Memorandum
Department of Planning and Development
Planning Division

To: Chair Delogu and Members of the Portland Planning Board
From: Rick Seeley, Senior Planner, GPCOG
Date: July 8, 2004
Re: July 20, 2004 Planning Board Meeting
Maine Medical Center Contract Zone
(Building Addition, Helipad, Parking Garage, and Central Utility Plant
Vicinity of Bramhall, Charles, Wescott, Ellsworth, Crescent, Gilman and
Congress Streets

EXHIBIT B, PAGE 14
PARKING GARAGE - EAST ELEVATION

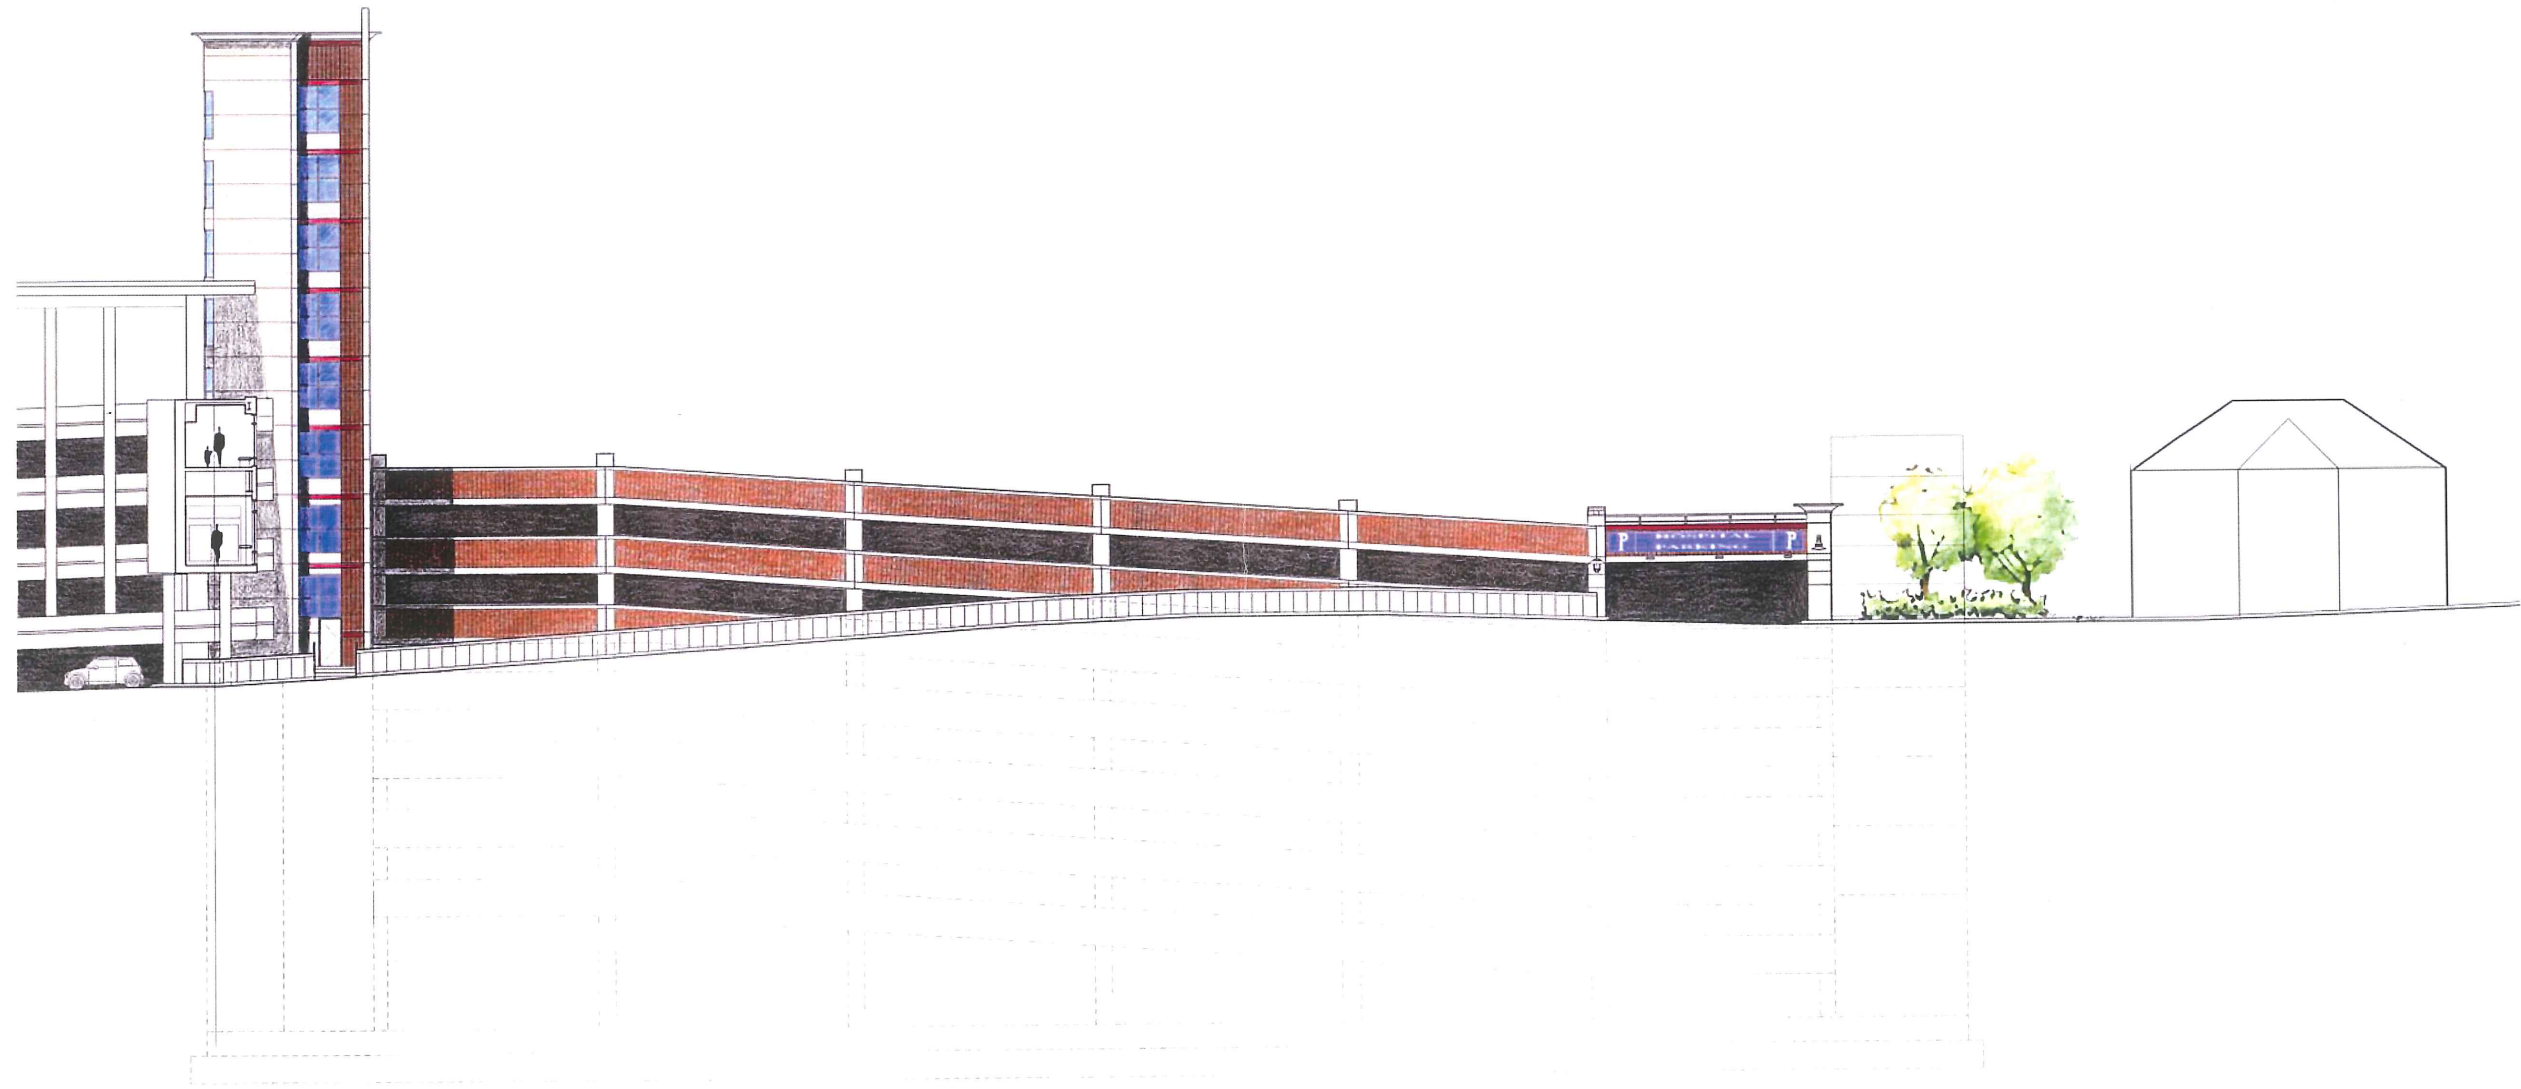
An elevation drawing of how this entrance and the related façade, on either the east side facing the neighborhood or the south side, facing the emergency department entrance, the Richards Wing, the Bean Building and the new Charles Street addition has not yet been submitted – although the an elevation concept was presented for the east end. Staff is still requesting, but has not yet received, elevations drawings showing an elevation view of the Crescent Street entrance and the southeastern corner of the new parking garage. What specific design elements such an elevation view will show, will depend at least in part on the Planning Board's guidance at the July 20th workshop.

The application describes but the concept elevation does not show shielding on the upper stories to limit headlight glare onto neighboring residential uses, unless this is the normal height wall for each level. This shield should be shown in the elevation view requested.
